Lorenzini Waterfront Residence

Mercer Island, WA

CD FRAMING REVISION CALCULATIONS

December 10, 2021

S2.0

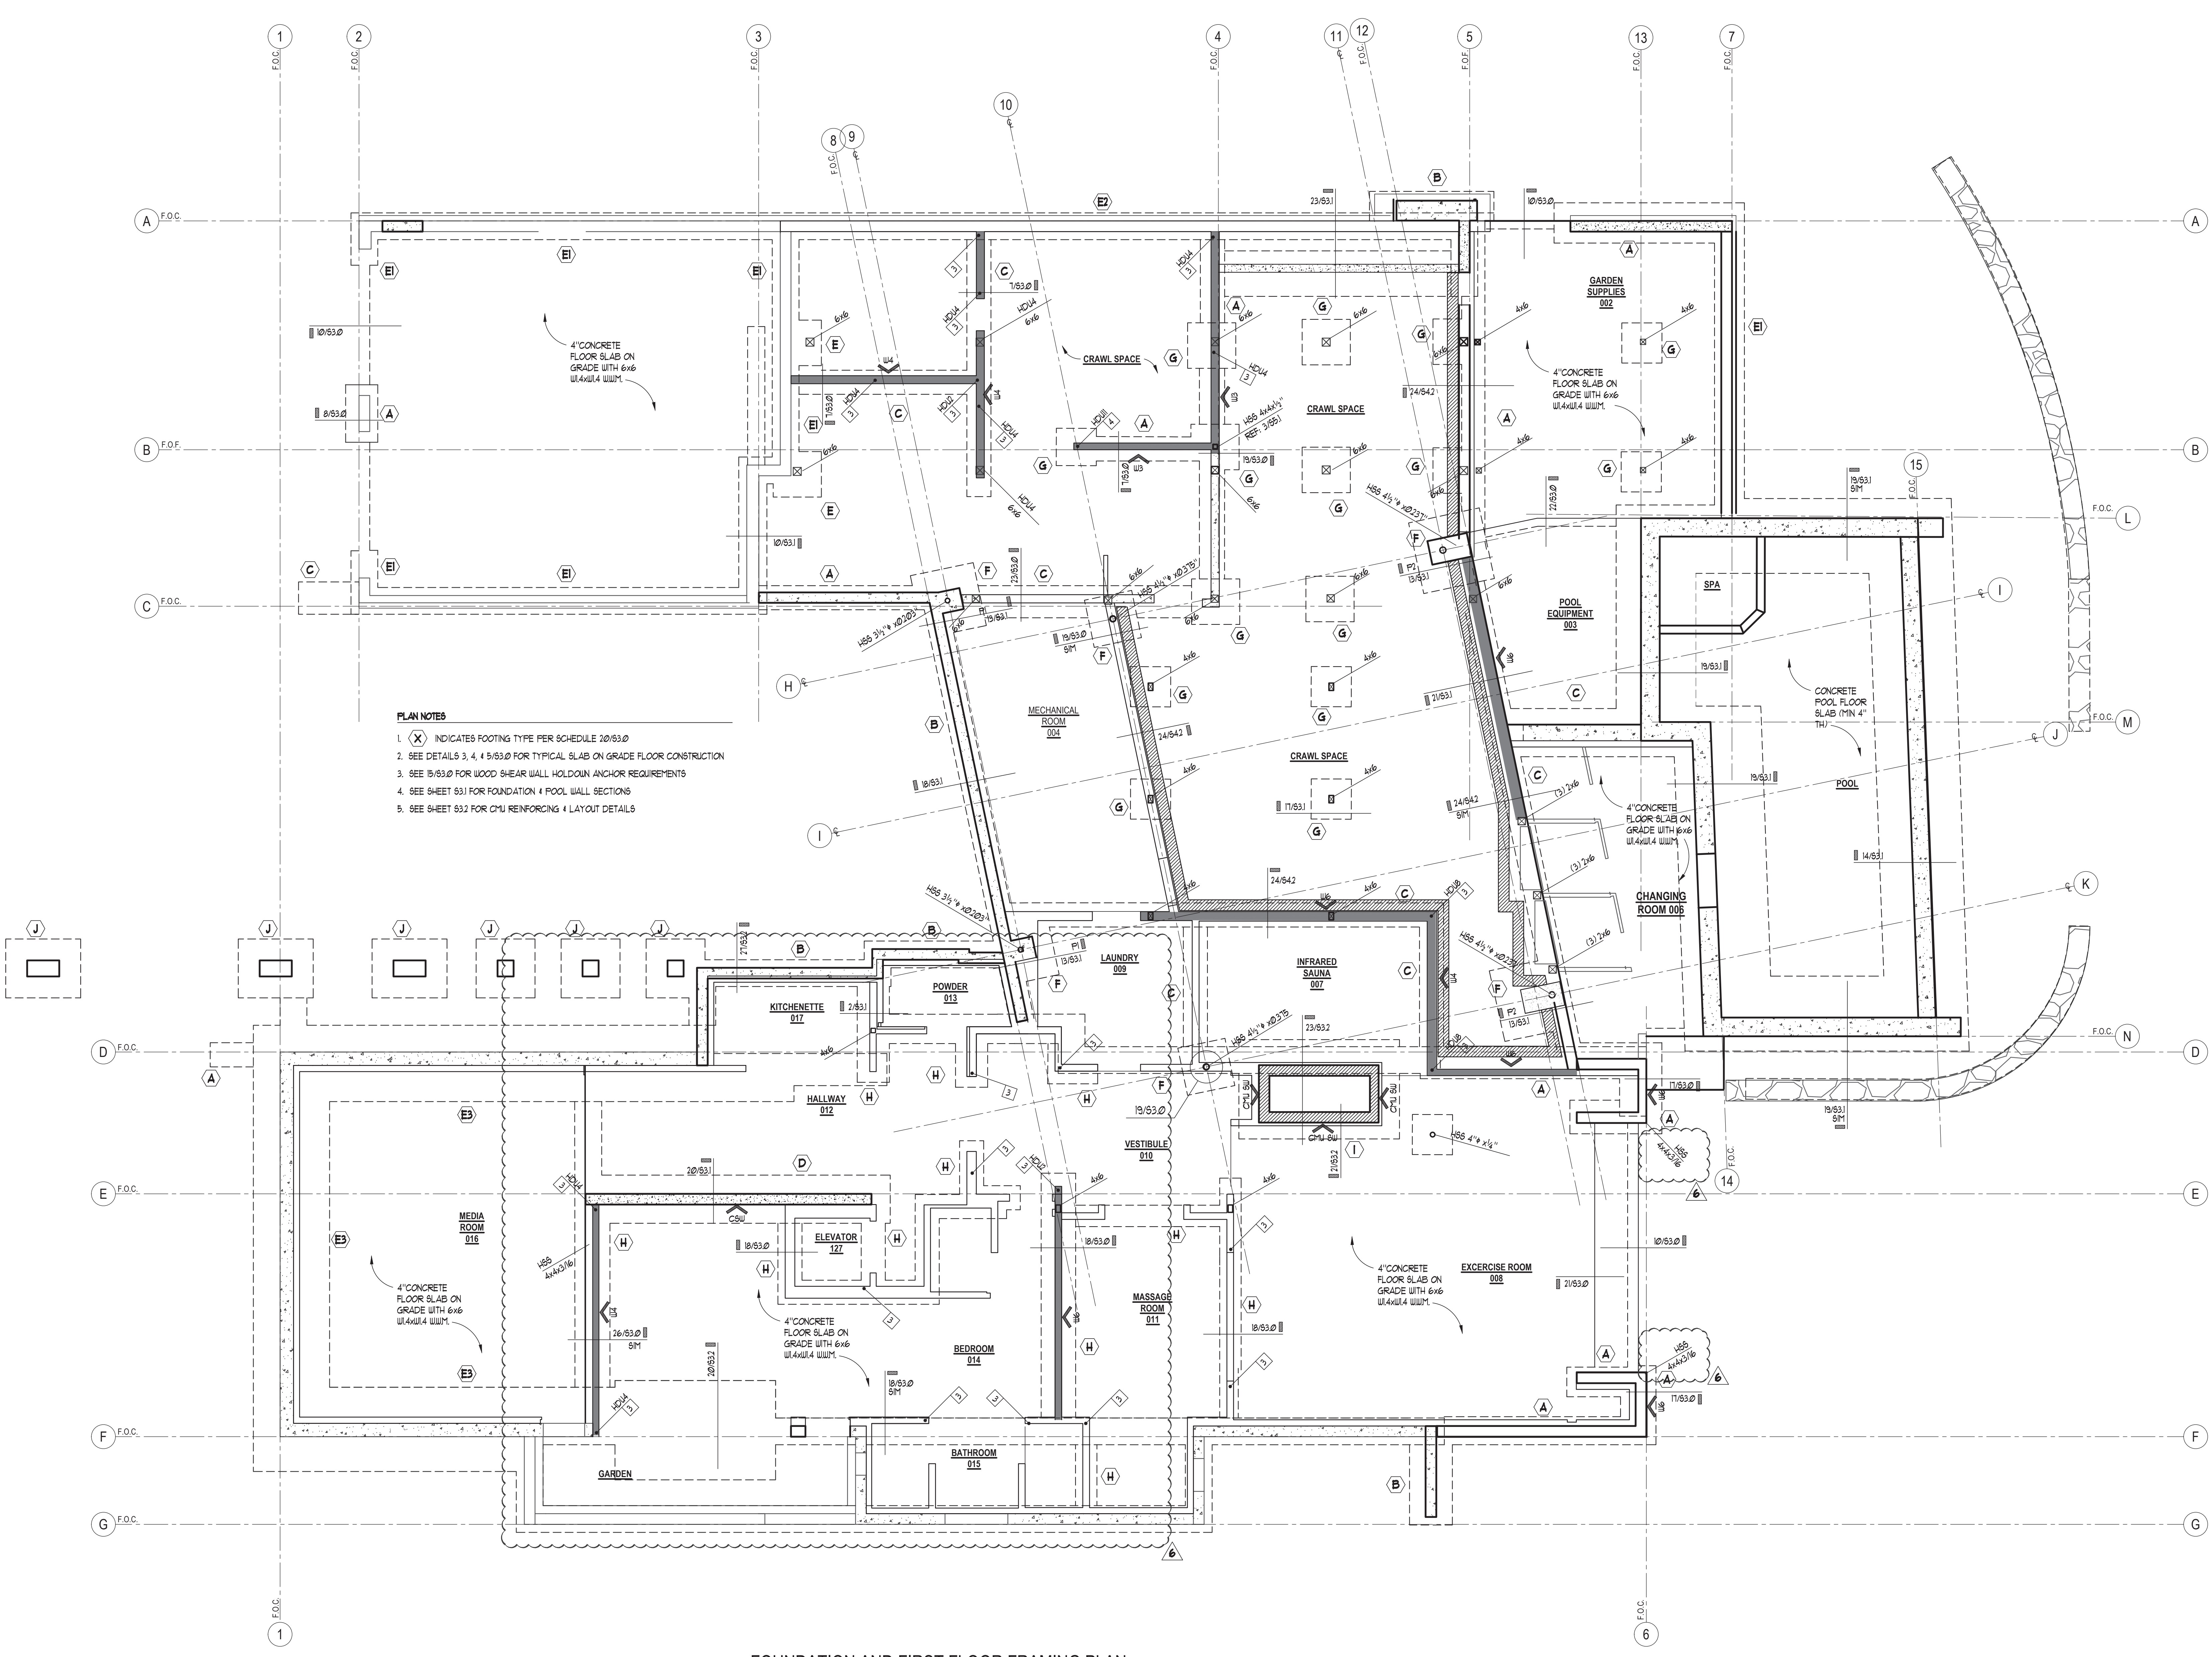
- S2.0 – Foundations and wall layouts revised for planning changes and new elevator in east wing
- S2.1 – Walls updated for new bathroom and entry layouts to accommodate new elevator. Framing revised to accommodate updated floor assemblies with flush finishes at bathrooms and terrace areas.

S2.1

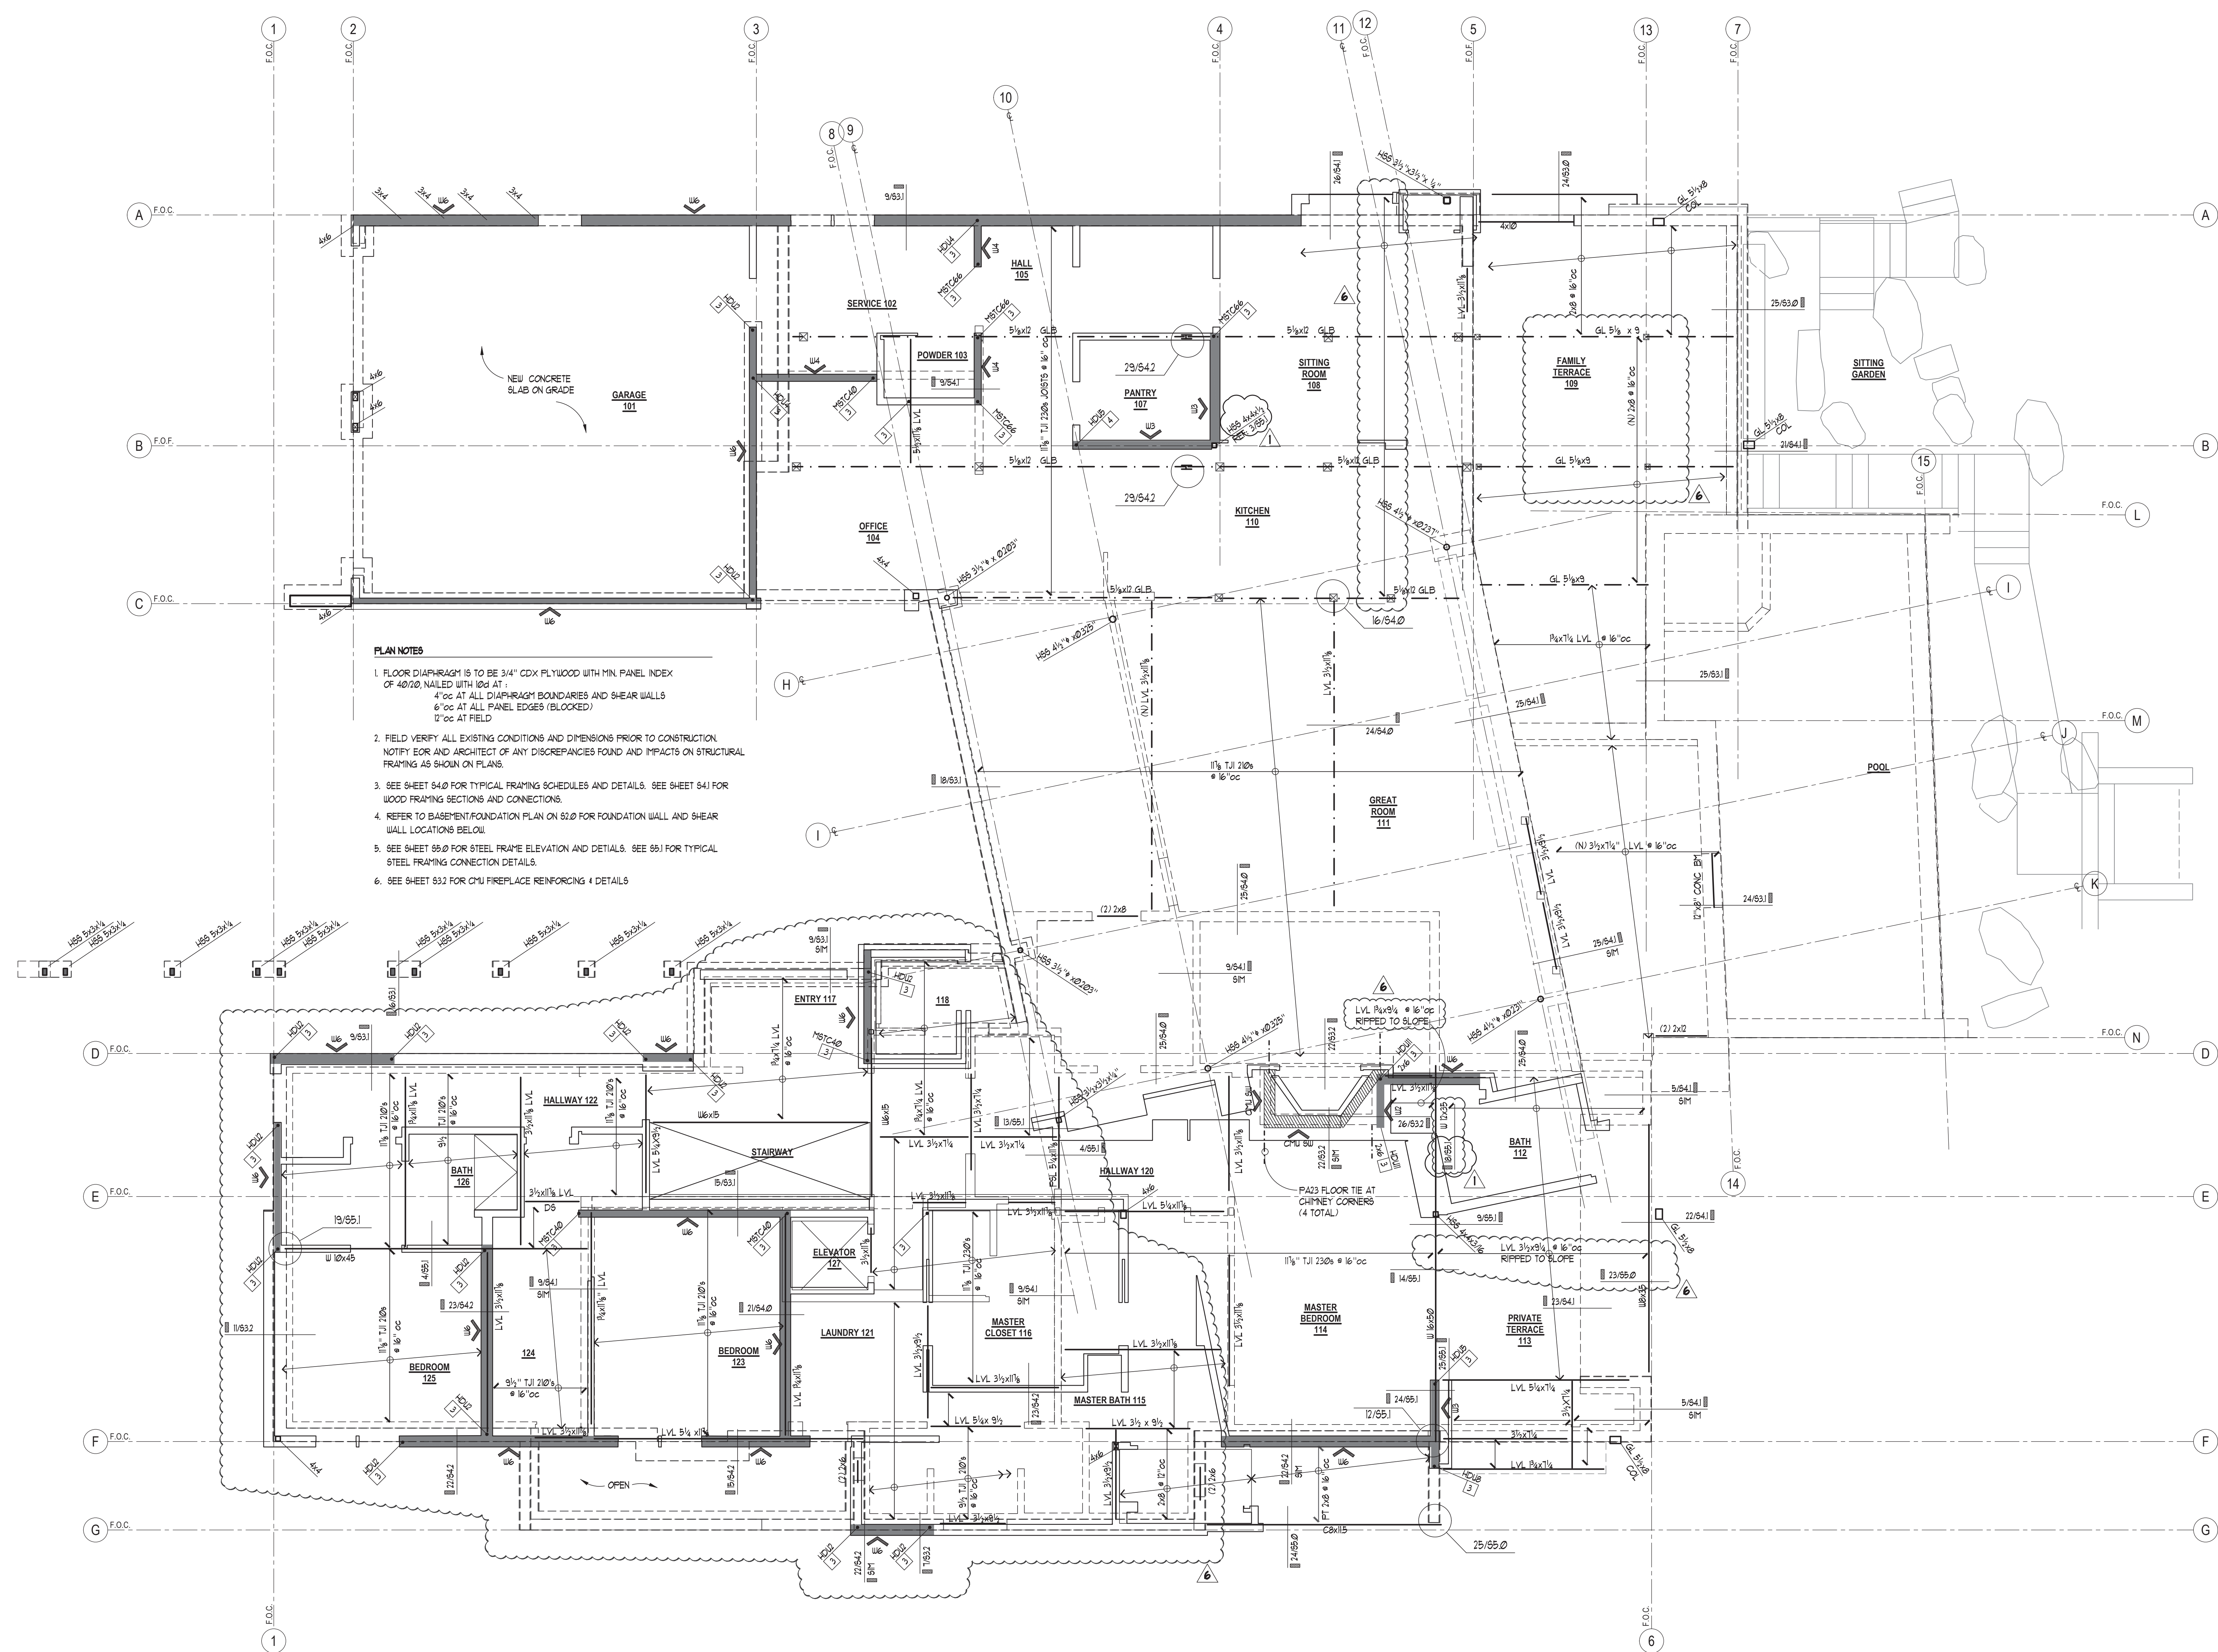
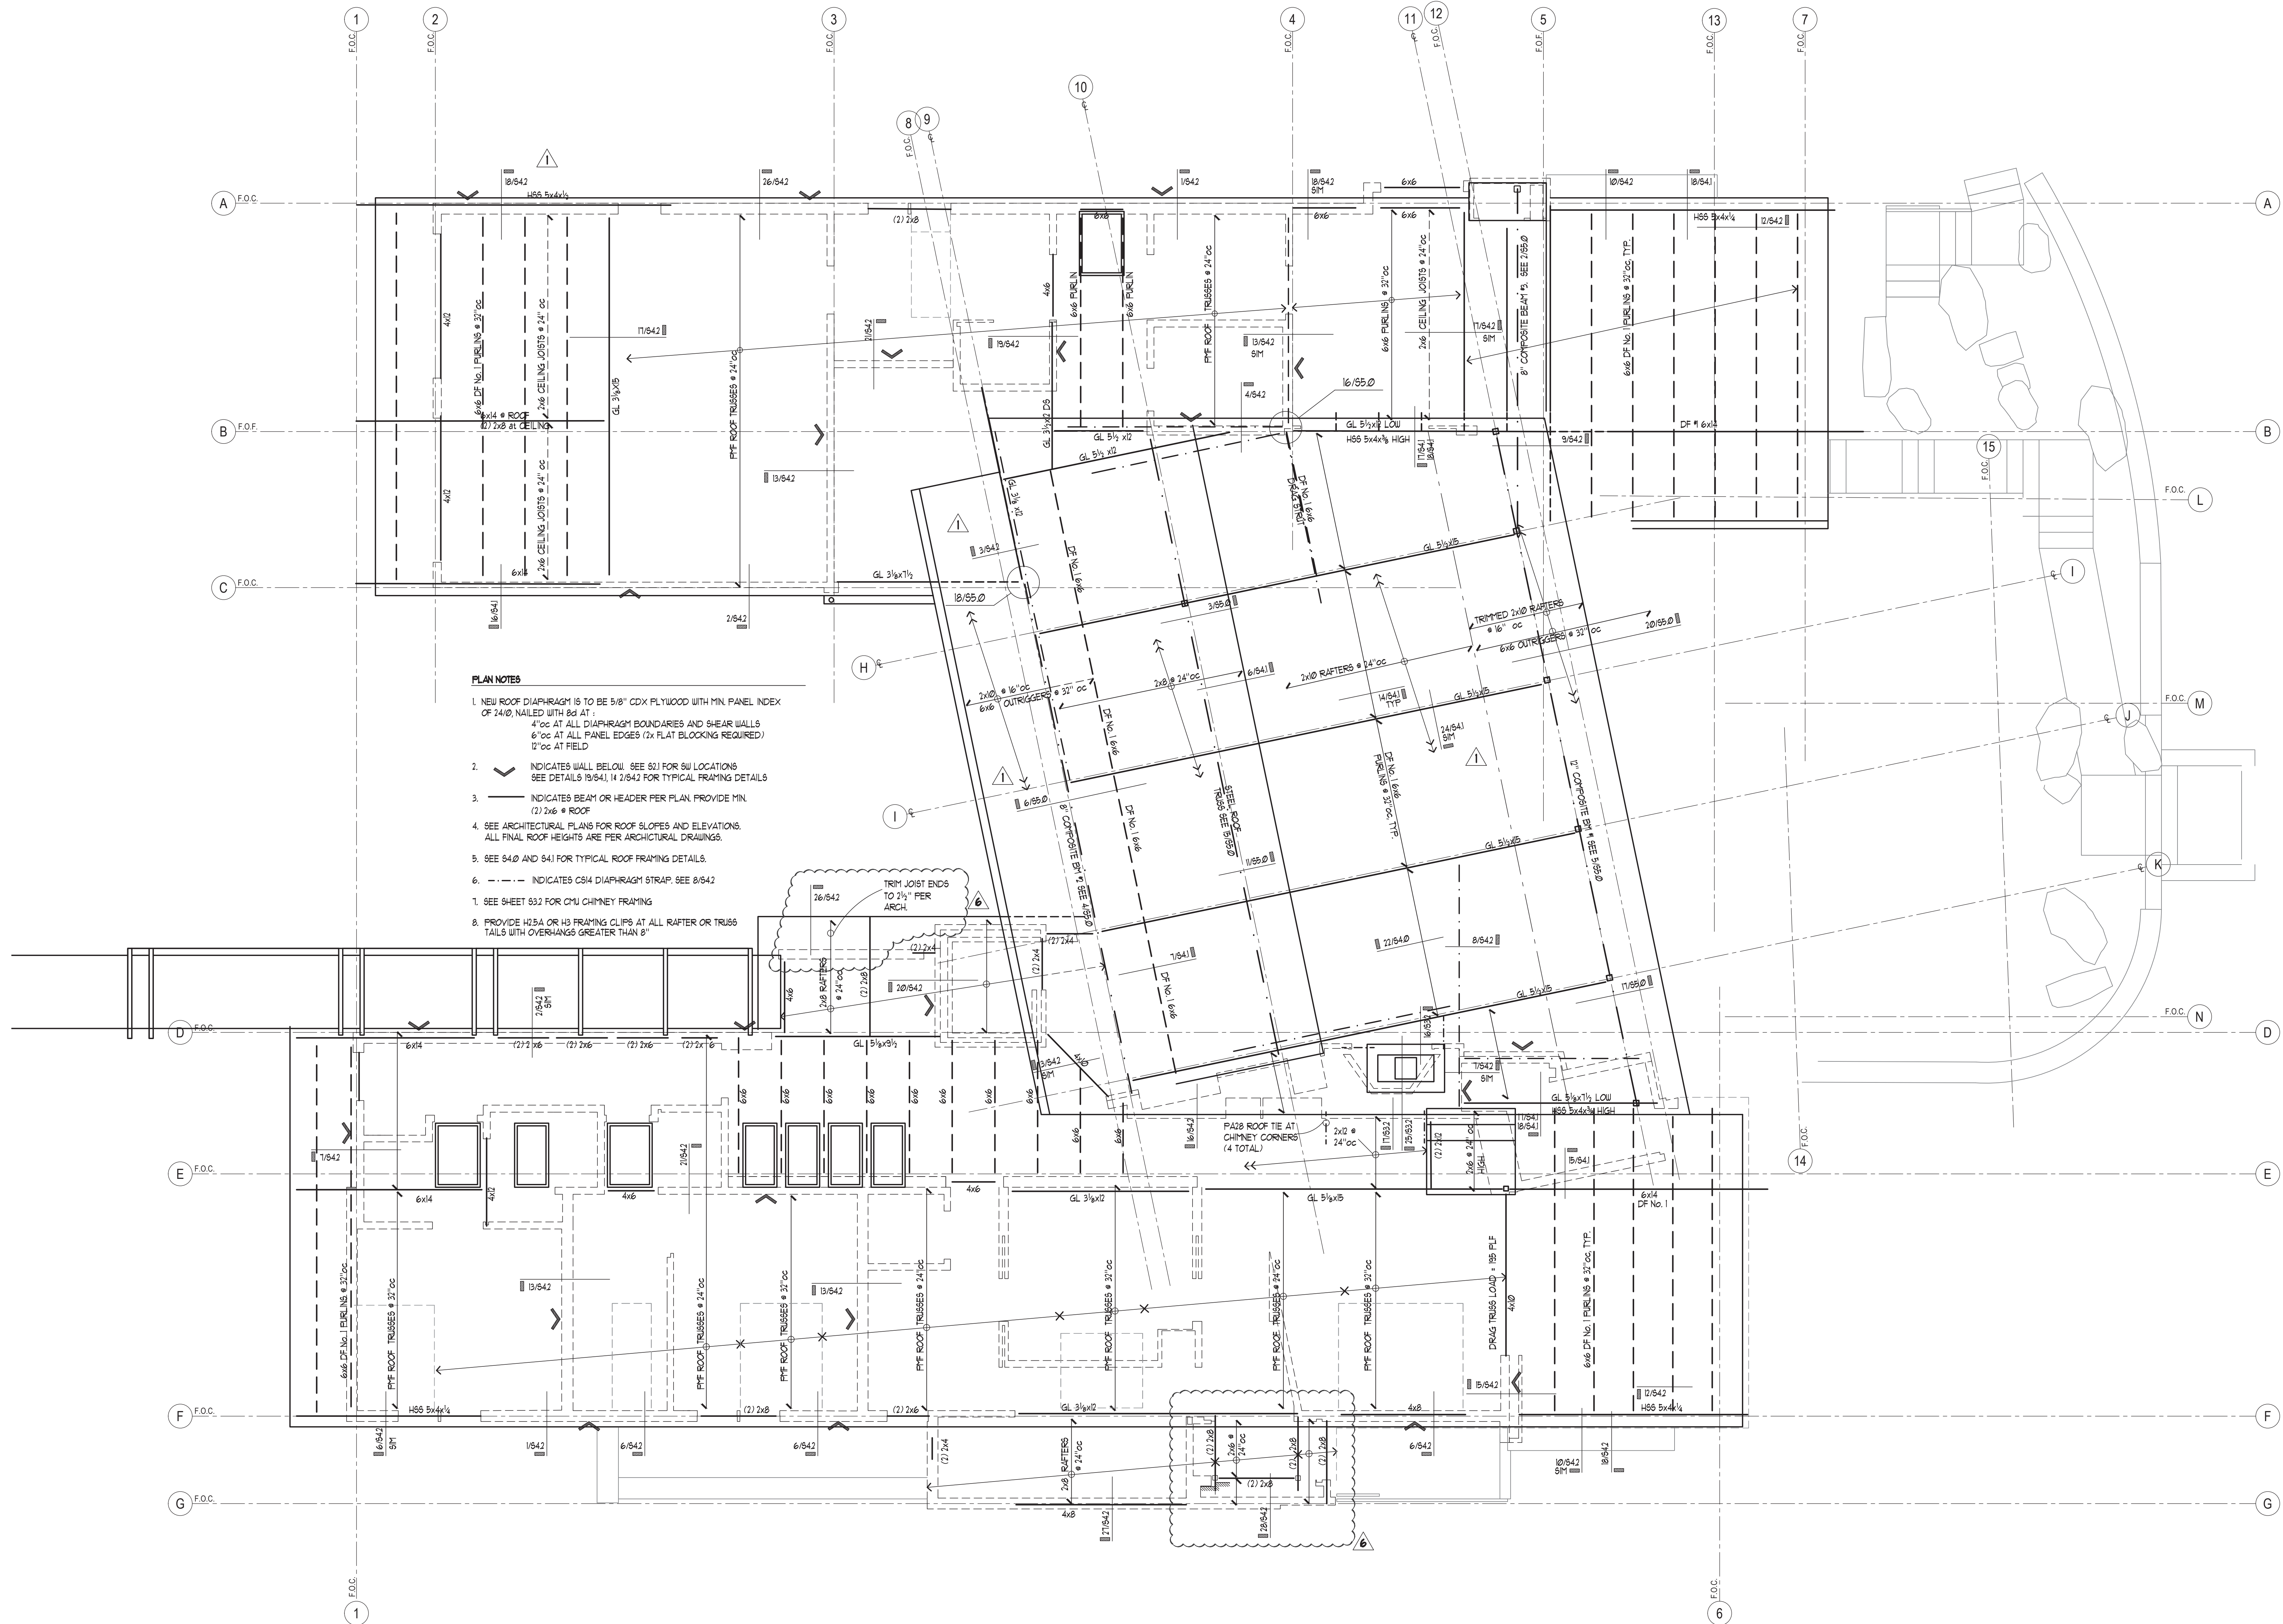
MAIN FLOOR FRAMING
EAST WING KEY

Revised CD Framing of Media Room (C Bath 126)
FR24
